From: Joyce Christie <Joyce.Christie@Cherwell-DC.gov.uk>
Sent: Friday, August 4, 2023 12:36 PM
To: Imogen Hopkin <Imogen.Hopkin@cherwell-dc.gov.uk>
Cc: DC Support <DC.Support@cherwell-dc.gov.uk>
Subject: 22/03308/LB North Arms Wroxton

Change of use from public house to one dwelling (associated with approval 22/00256/F), single storey rear extension, internal and external alterations with Conversion of existing outbuilding to ground floor garage with first floor ancillary accommodation

D&A/Heritage Statement May 2023
D&A Supporting Statement June 2023
Planning Statement June 2023
New Drawings June 2023
(Reconsult sent 03.07.2023)

CELLAR SECTION 1:50

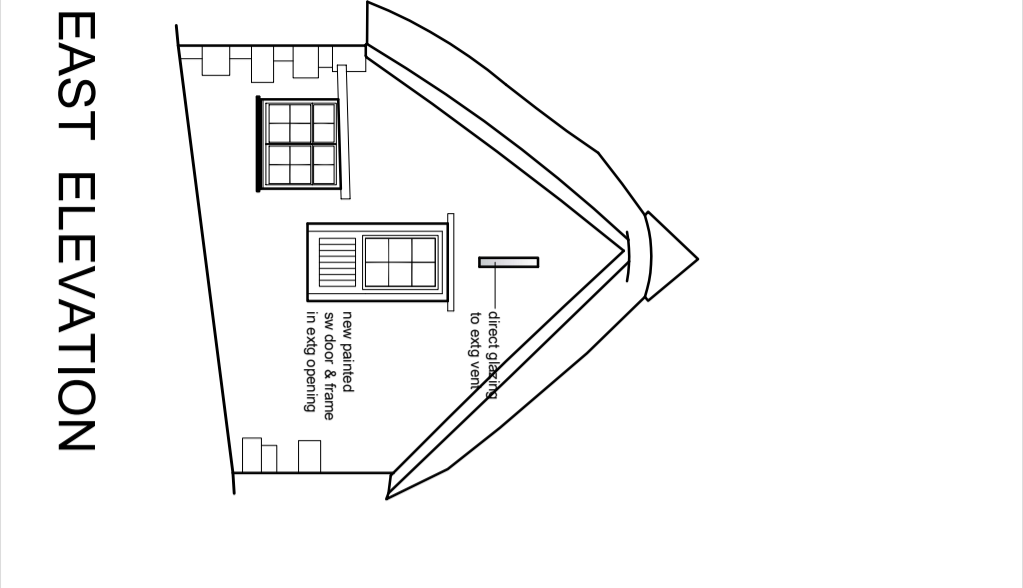
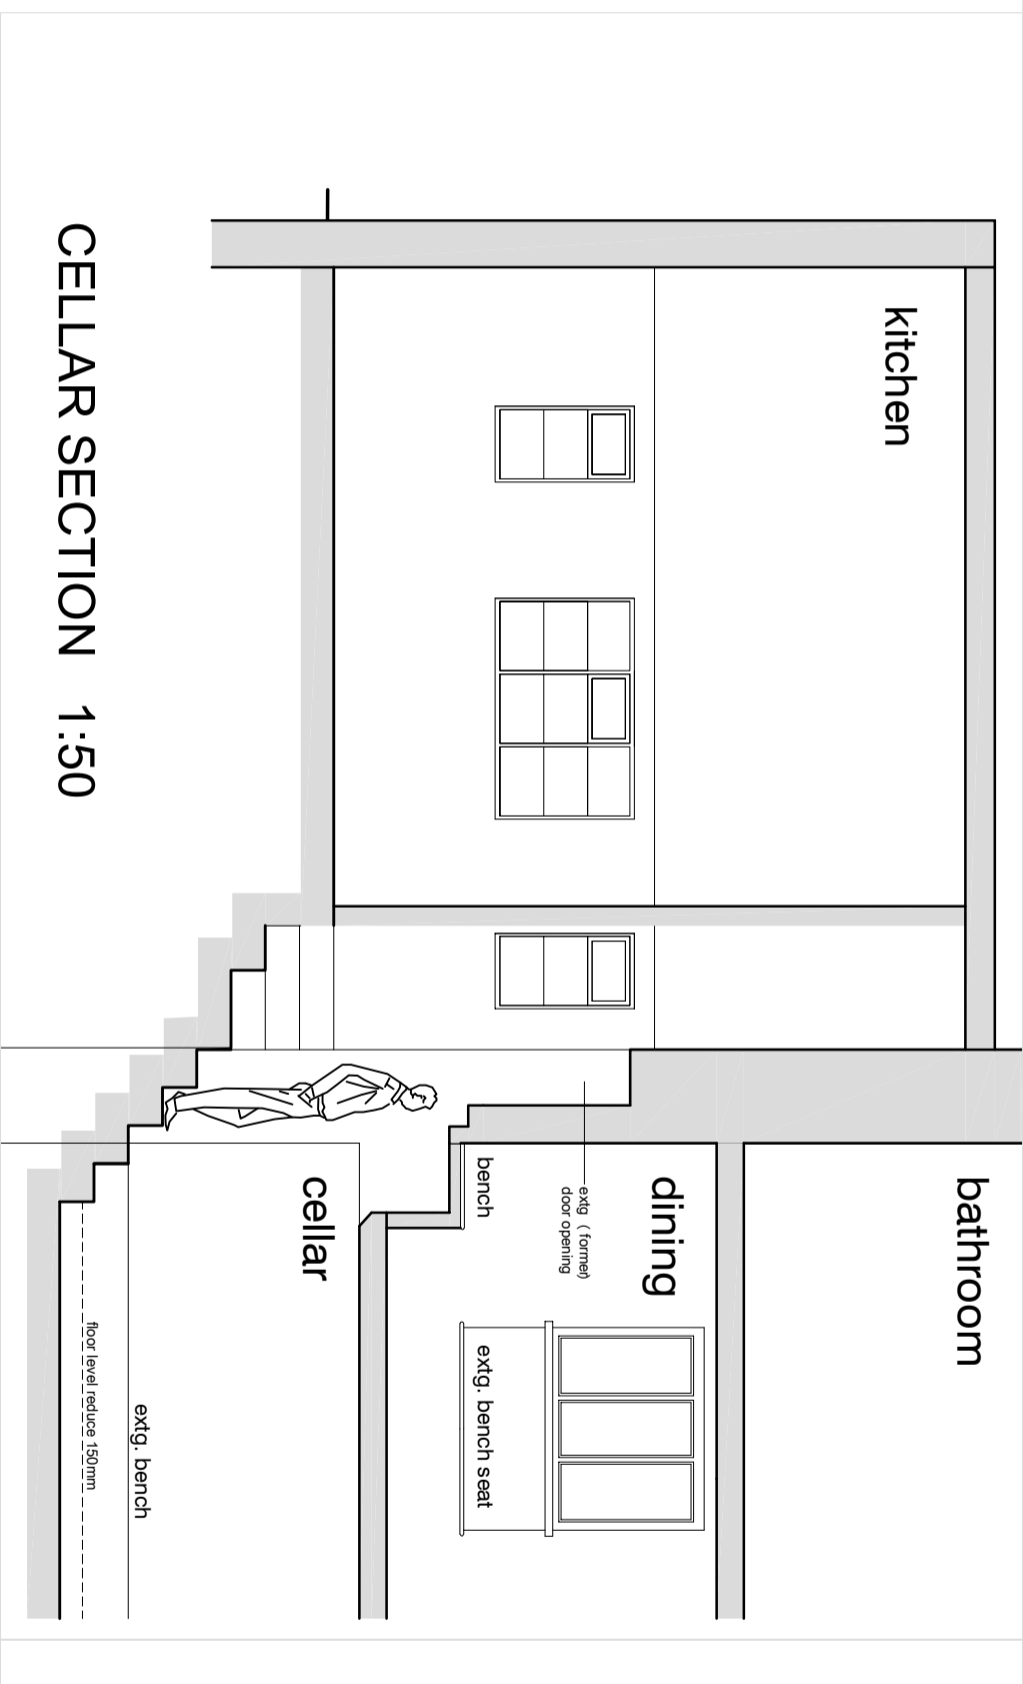
THE SECTION ON THE ELEVATION SHOWS THE FLOOR TO BE DREDUCED BY 150 – WE NEED A METHOD STATEMENT AND CONFIRMATION THE FOOTINGS WLL NOT BE UNDERMINED. IF ORIGINAL FLAG FLOR THS NEEDS TO BE RECOORDED LIFTED AND RIENSTATED.
WE NEED DETAILS OF THE PROPOSED LINTELS FOR THE OPENING AND METHOD STATEMENT.

WE WOULD ACCEPT CRITTALL STYLE WIDNOWS IF THEY WERE SIDE OPENING CASEMNETS – WE DO NOT SUPPORT THE TOP HUNG CASEMENTS AS SHOWN – DETAILS WILL BE NEEDED. ENSURE A DECENT SET BACK FROM THE WALL FACE.

THE CATSLIDE ROOF AND PROJECTION IS NOT SUPPORTED.

EAST GABLE DOOR – DETAIL OF CAN BE CONDITIONED.

NEW MULLIONED WINDOWS WITH METAL SIDE HUNG CASEMENST AND FIXED LIGHTS – DETAILS TO BE CONDITIONED, THE PROPORTION FO GLAZING WOULD BE MPROVED BY INSERTING HORIZONTAL GLAZING BARS
